**Yarren Hut Solar Farm (SSD 10415)  
Request for Additional Information**

I refer to the Department's assessment of the Yarren Hut Solar Farm (SSD-10415). After careful consideration, the Department is requesting that you provide additional information.

Yarren Hut Solar Farm
Mitchell Highway / Site Access Intersection
Access Design

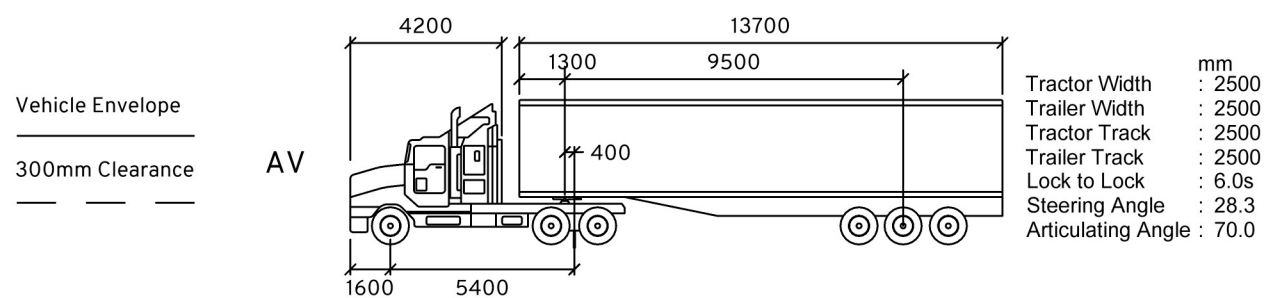
- Provide details of a Basic Right (BAR) turn upgrade intersection treatment of the site access with the Mitchell Highway consistent with the Austroads *Guide to Road Design* and Transport for NSW (TfNSW) requirements.
- Provide confirmation of the lots impacted for the revised intersection treatment (i.e. if it is accommodated wholly within the Mitchell Highway road reserve or impacts private land).
- Provide an assessment of the impacts the revised intersection treatment may have on the affected land, including impacts on biodiversity and heritage.
